FULL

Reference:	H08-0852-25	Date of Decision:	6th November 2025
Applicant:	Mrs K M Baxter C/O Longstaff 5 New Road Spalding Lincolnshire PE11 1BS		
Location:	Belnie House Farm Buildings Belnie Lane Gosberton Spalding		
Description:	Demolition of Existing Barns & Erection of 2 Dwellings

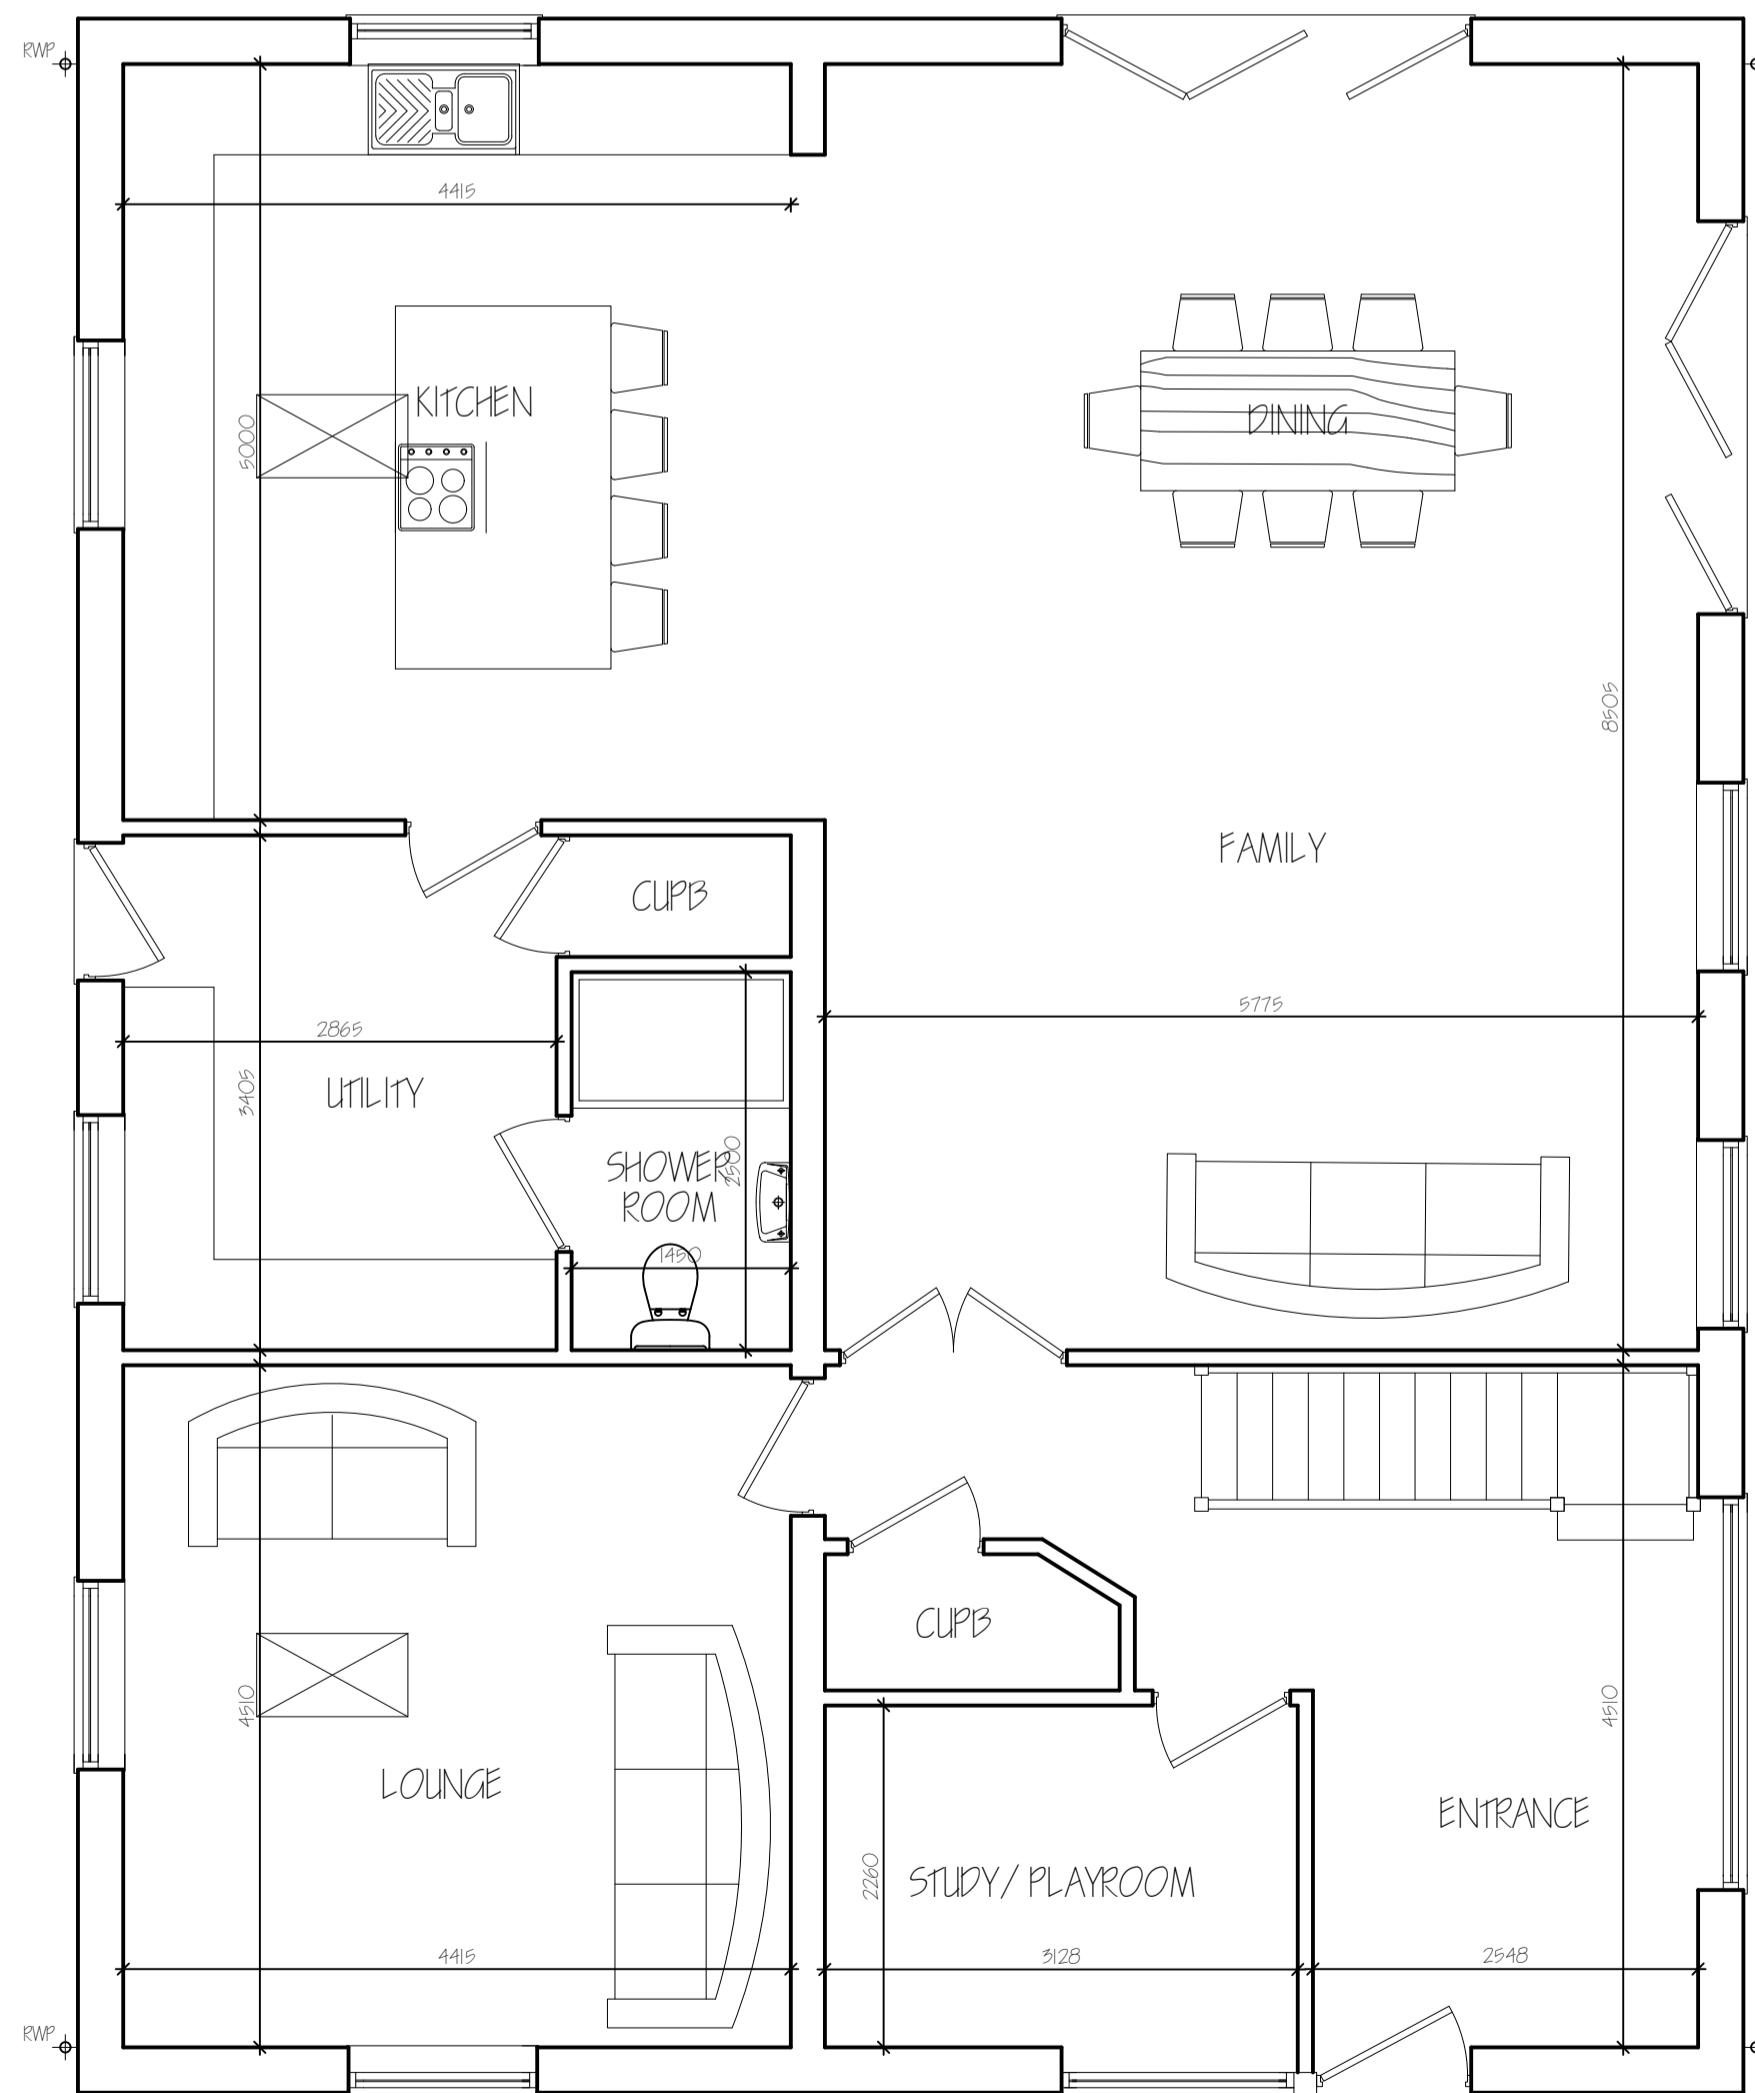
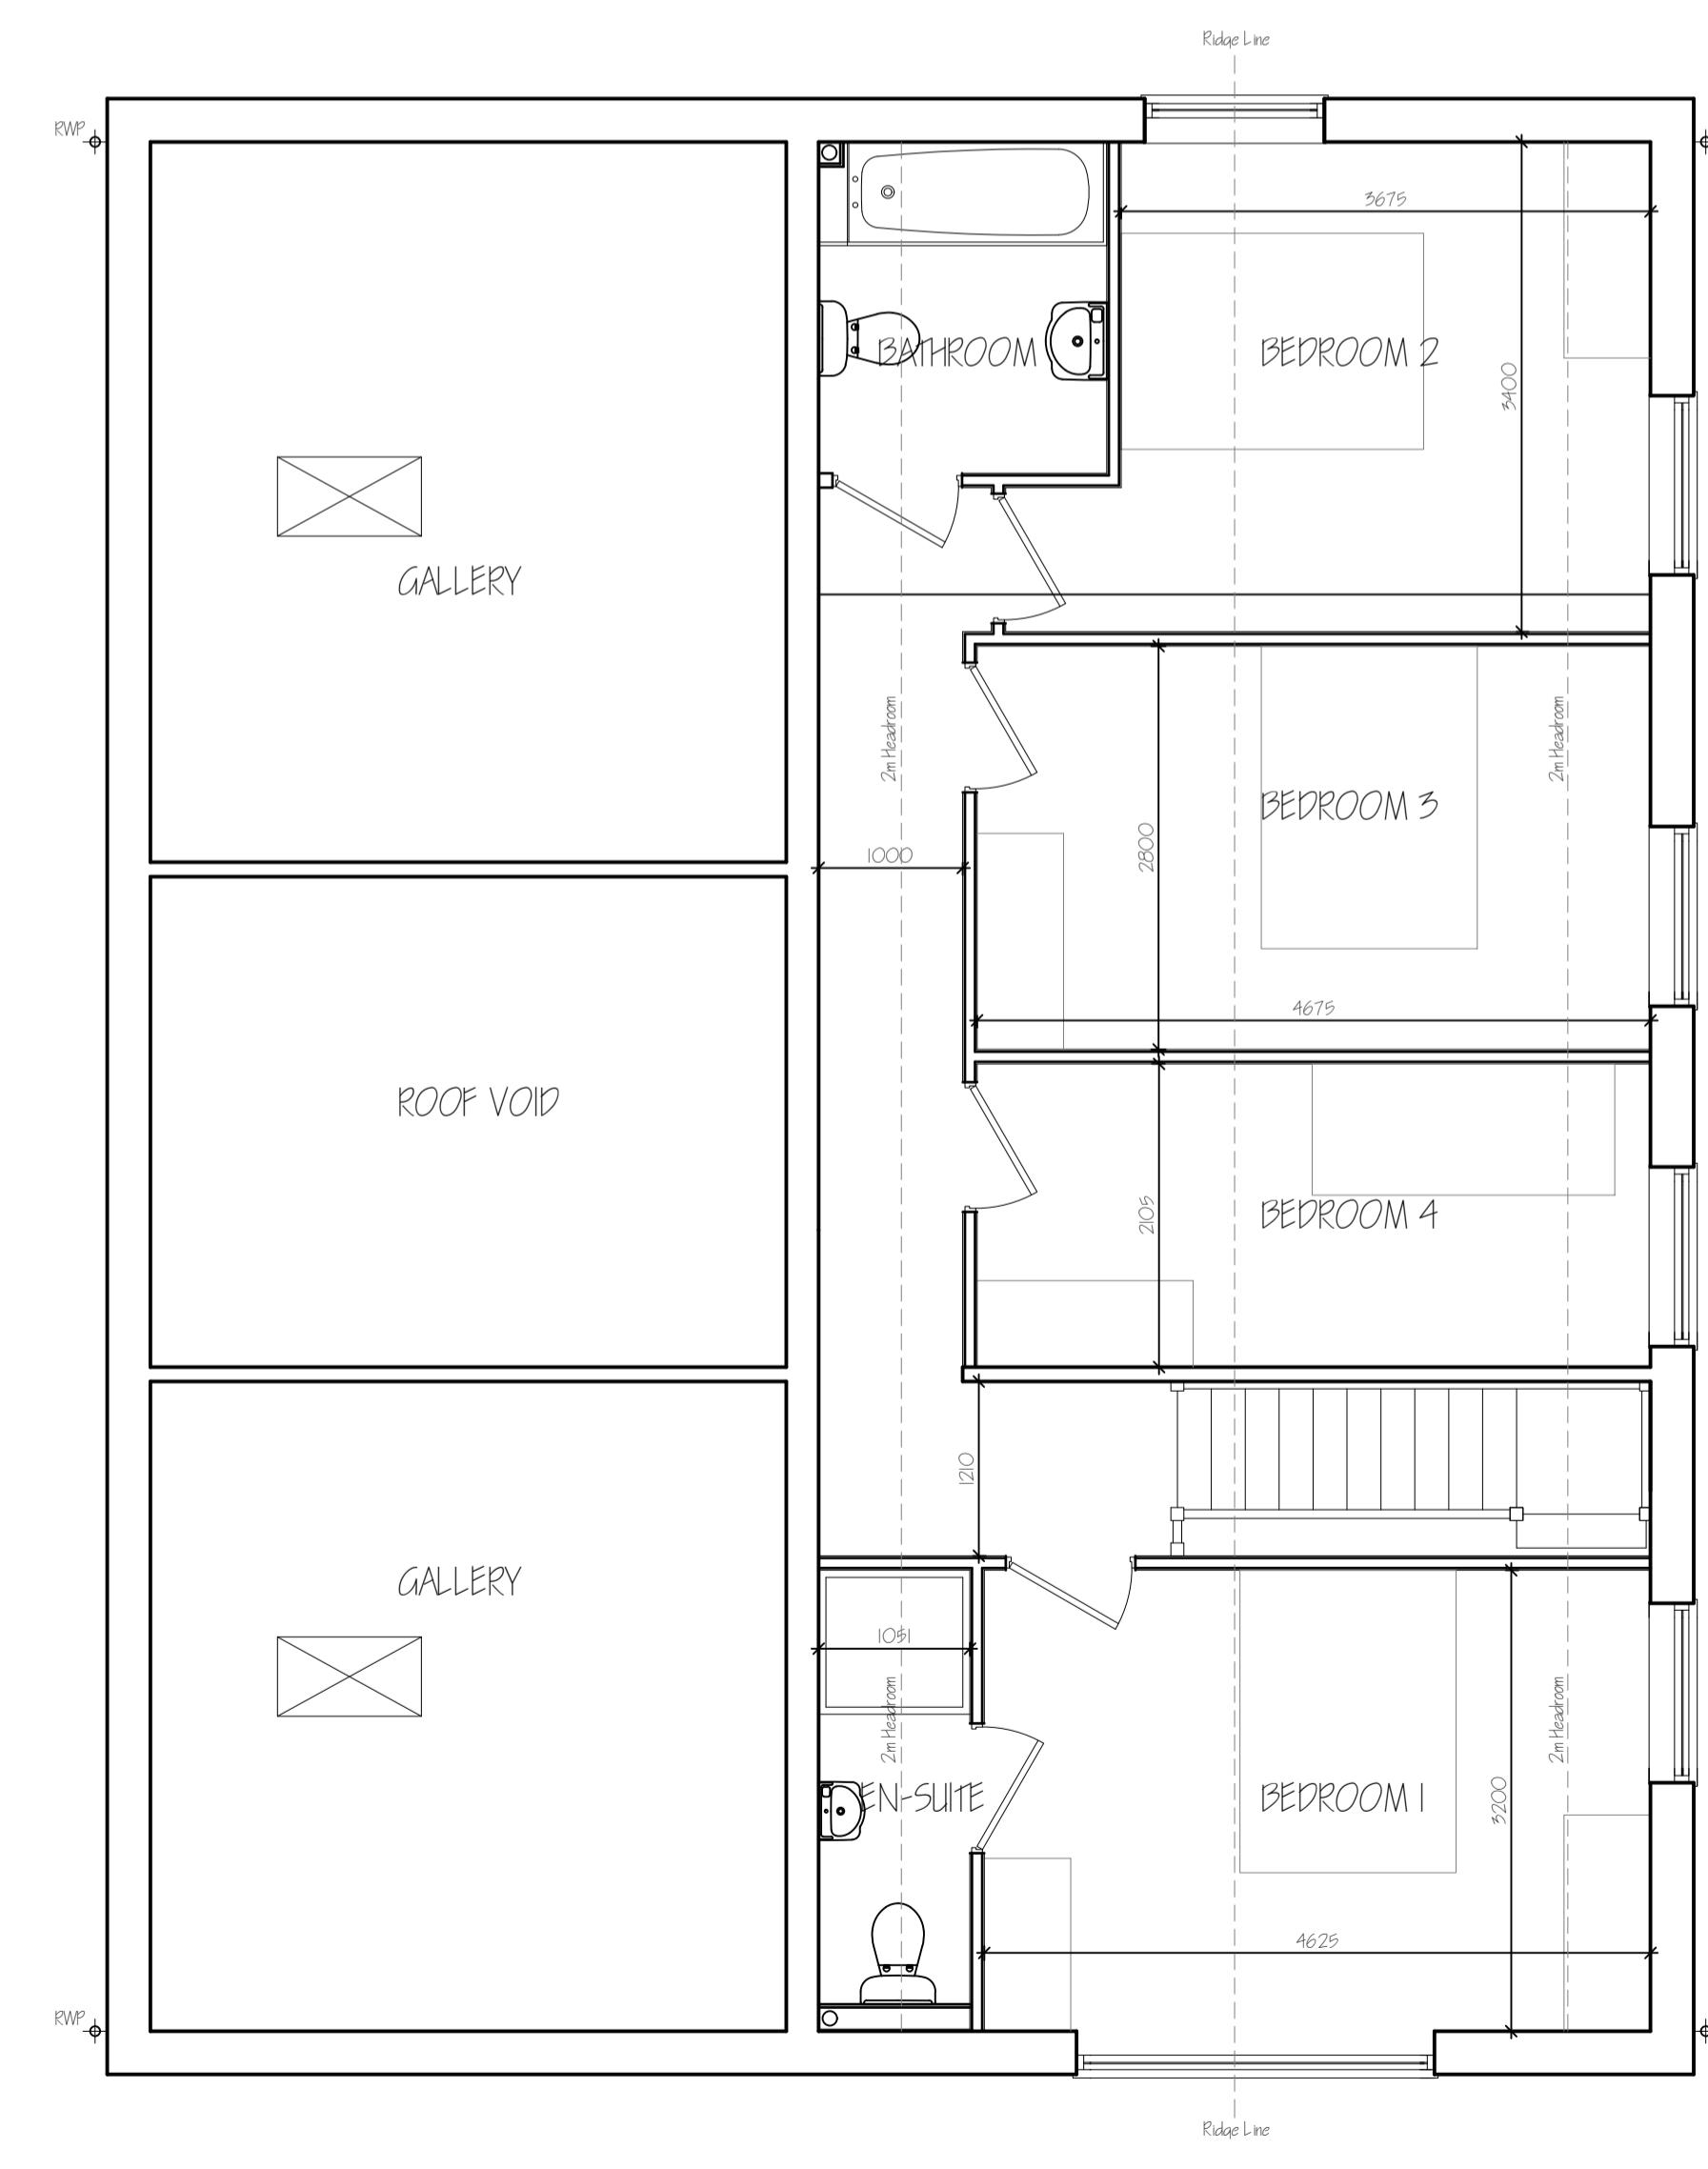
- 1 The proposed development is considered to be of limited architectural merit which would be at odds with the countryside context of the site. If approved, the development would have a more urbanising effect upon the area, than the development that has been approved under the prior approval consents within the site (H08-0970-24 and H08-0972-24). The proposal is not considered to represent betterment, over what has already been approved on this site and the proposal is considered to be contrary to the aims of Policies 2 and 3 of the South East Lincolnshire Local Plan, 2019 as well as Paragraph 187b of the National Planning Policy Framework, December 2024.
